# ANNEXURE 5

## RESPONSE TO MATTERS RAISED DURING PUBLIC SUBMISSION – RECONFIGURATION OF CRONULLA MARINA

Figure 6 – Proposed Slipway Layout

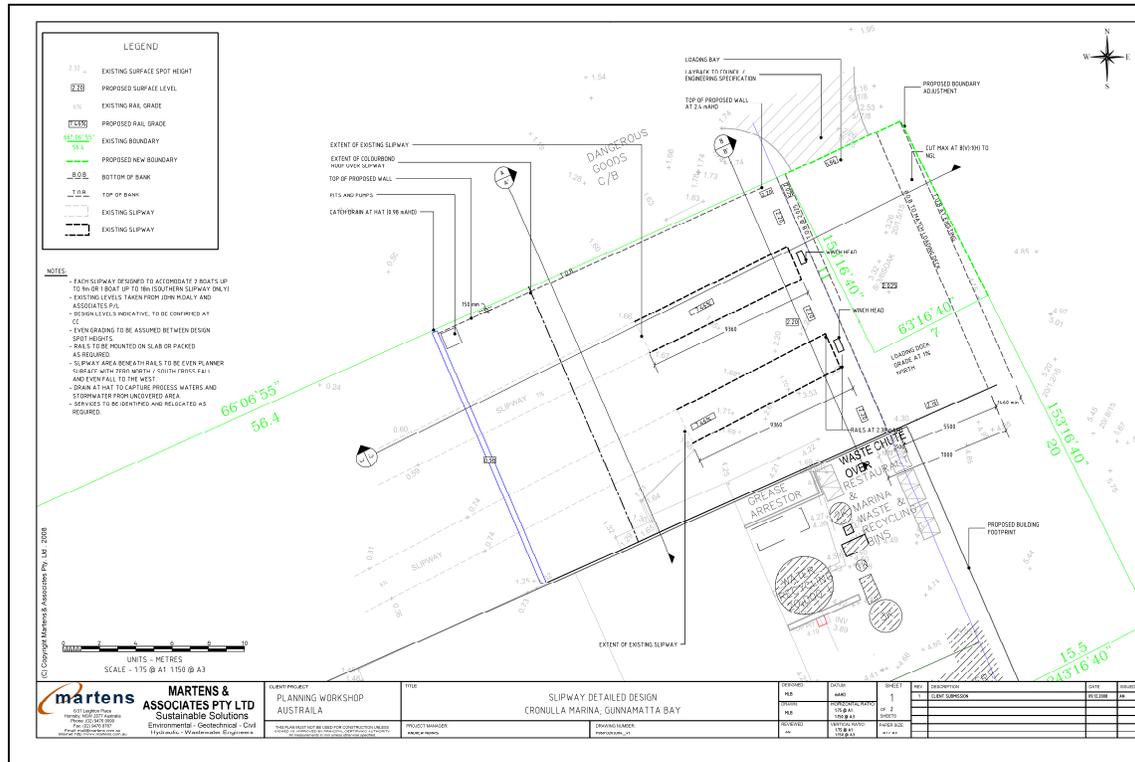
<p><b>The proposed palisade fence around slipway will create a fortress like effect around the slipway. The significant height and structure (masonry wall</b></p>	<p>The slipways are currently enclosed by a mesh fence.</p> <p>The proposed slipway awning has been carefully designed using similar architectural language to that of the adjoining Cronulla Marina land based facility. It is within the same form and scale. The awning is proposed to provide an appropriate work environment in all weather conditions and quite importantly, to improve the environmental management of the slipways, thus</p>

<p><b>and palisade) is not in keeping with the local area</b></p>	<p>further reducing impacts on the marine environment.</p> <p>The proposed replacement fence is predominately palisade with masonry columns and is more durable than the existing fence. The height (1.8m) addresses security matters.</p>
<p><b>The marina lighting will have an appearance of a fair ground</b></p>	<p>AS indicated in the Environmental Assessment, “down lighting” will be provided along the walkways and to the piles, using the “M-Tech Pedestal type model with a 15w compact fluoro globe.</p>
<p><b>No community benefit</b></p>	<p>Significant community benefits will flow from the proposed development. In addition to the <b>Conditions of Consent</b> (DA06/0923) imposed by Sutherland Shire Council which required:</p> <ul style="list-style-type: none"> <li>• enhanced road frontage works;</li> <li>• installation of a disabled parking space at the upper level;</li> <li>• an internal stair climber to allow persons with a disability access to the lower level of the land based Cronulla Marina facility and access to the adjoining Public Ferry Wharf</li> </ul> <p>and the Crown Reserve Works which required:</p> <ul style="list-style-type: none"> <li>• improved and safer pedestrian and disabled access to the marina and the adjacent Public Ferry Wharf;</li> <li>• road works;</li> <li>• paths, steps, handrails; and</li> <li>• landscape works,</li> </ul> <p>the following major community benefits public benefits will be created by the proposed development:</p> <ul style="list-style-type: none"> <li>• It will create safe and secure access to vessels for all persons including children, the aged and disable members of the local community and visitors to the area.</li> <li>• This differs from the majority of existing marina berths in Port Hacking which are of the older fixed wharf structure which, in waterways with a seasonal tidal variation of some 2 metres rise and fall, makes these berths unsuitable as they do not allow safe access to and from vessels by children, the aged or disabled members of the community. The proposal addresses this local issue by proposing a floating berth marina complex;</li> <li>• The proposal removes six piles and six fingers either side of ‘A’ arm to reconfigure this arm for public, water taxi service and houseboat access;</li> <li>• Publicly accessible facilities including new fuel facility, marine servicing, sewerage pumpout facilities and toilets;</li> <li>• The proposal satisfies some of the growing local community demand for modern serviced marina berths from which they can pursue recreational boating activities with their family and friends.</li> </ul>

Figure 7 – Overlay of the Original (Marked in Red) and Revised Site Area (Marked in Black)

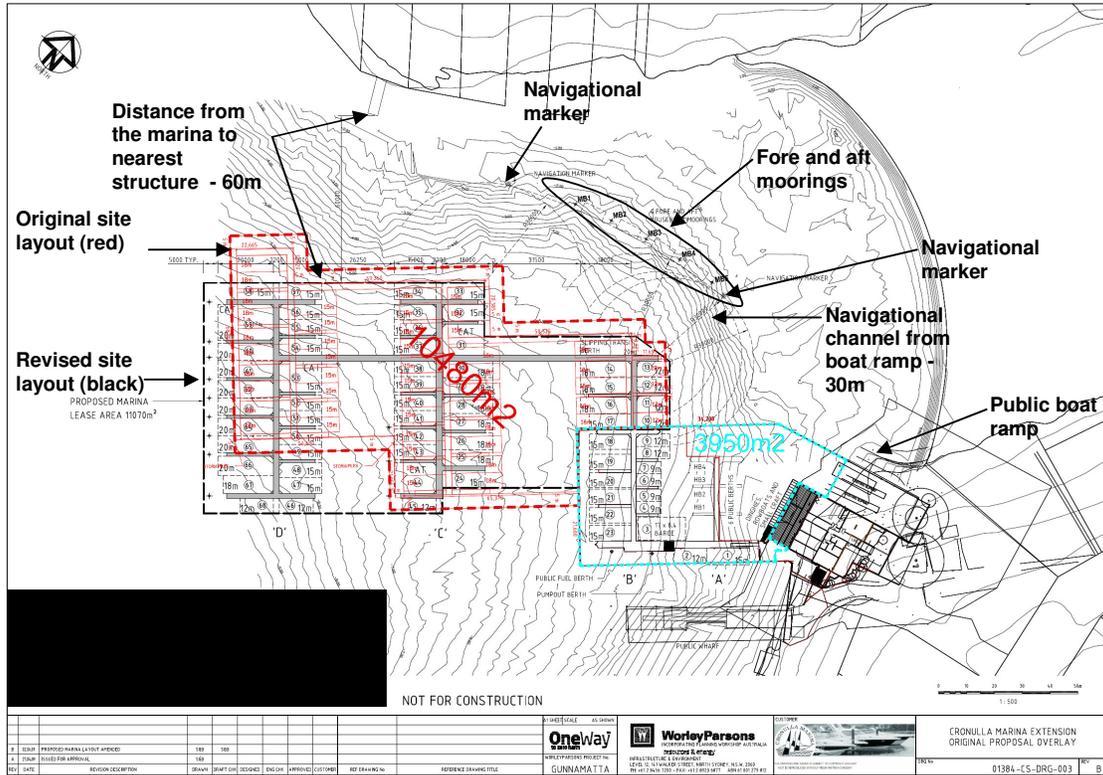
<p><b>Width of the proposed facility</b></p>	<p>NSW Maritime in their submission dated 5<sup>th</sup> November 2008, state:</p> <p><i>“Provision needs to be made to allow greater width in the navigation channel accessing Tonkin Park Public Boat Ramp whilst maintaining the same footprint on the alternate (Gunnamatta Wharf) side of the proposal.</i></p> <p><i>To accommodate this requirement it is envisaged that five berths within the proposed marina extension will need to be deleted. These include berths 21, 26, 48, 49 and 66.”</i></p> <p>NSW Maritime suggests the removal of 5 berths as it deems the <i>“overall width of the proposed facility...to pose a hazard to navigation.”</i> NSW Maritime bases its request on the following <i>“to allow greater width in the navigation channel accessing Tonkin Park whilst maintaining the same footprint on the alternate (Gunnamatta Wharf) side of the proposal....”</i></p> <p>NSW Maritime nominates berths 26, 48, 49 and 66 for removal, which lie on the southern side of the marina. These berths have no impact on (or relationship to) the navigation channel from the public boat ramp, located on the northern side of the</p>

<p>The width of the navigable channel from Gunnamatta Bay around vessels berthed at the proposed marina into the public boat ramp is less than 15m</p>	<p><i>head at the NW corner of the original proposal and reorganising the northern end of C-Arm.</i></p> <p><i>Further discussions between Cronulla Marina and NSW Maritime have canvassed the preferred locations for the 4 fore-and-aft moorings. GBA understands that positioning the five mooring blocks at least 30 m from the floating marina would be considered acceptable to Maritime. The proposed alignment of the fore-and-aft moorings, parallel to the navigation channel, would serve as a guide for vessels navigating to and from the public boat ramp."</i></p>
<p><b>Proposal pushes marine traffic from the public boat ramp to the northern shore of the bay where it is directed across sea grass beds</b></p>	<p>As discussed above, the 4 existing houseboat moorings will be relocated 30 m north of the reconfigured marina, as fore and aft moorings, to assist navigation to and from the public boat ramp.</p> <p>A clearly defined 30m wide unobstructed channel will direct marine traffic from the public boat ramp into the deeper water away from the sea grass beds along the north-western shoreline.</p>

<p>marina. Further, all access to these berths is gained from the south and in no conflict with the navigation access channel to the public boat ramp (accessed via the north).</p> <p>There appears to be no other basis provided in the submission to support the removal of the abovementioned berths.</p> <p>In addition to the above points, the navigation channel between the floating marina structure and the closest fore-and-aft moorings (MB5 and MB4) increases under the proposed reconfiguration and improves the access to and from the public boat ramp (<b>See Response to Public Submissions - Public Boat ramp-Access Comparison -Figure 1 and 2</b>).</p> <p>Notwithstanding the above, our proposal includes a detailed Coastal Engineering Assessment (including consultations with NSW Maritime).</p>
<b>Loss of public access to an extensive area of public waterway</b>	<p><b>There will not be any change to the existing public access to the public waterway.</b></p> <p>Opportunities to improve public access to Cronulla Marina and the adjoining foreshore were addressed under the redevelopment of the land based facility (DA06/0923). The Notice of Determination (Development Consent) included Conditions of Consent imposed by Sutherland Shire Council, which required enhanced road frontage works, installation of a disabled parking space at the upper level and an internal stair climber to allow persons with a disability access to the lower level of the land based Cronulla Marina facility.</p> <p>In addition, under Condition 11 of DA06/0923 required <b>Crown Reserve- Works</b> including:</p> <ul style="list-style-type: none"> <li>• improved and safer pedestrian and disabled access to the marina and the adjacent Cronulla- Bundeena public ferry wharf;</li> <li>• road works;</li> <li>• paths, steps, handrails; and</li> <li>• landscape works.</li> </ul>
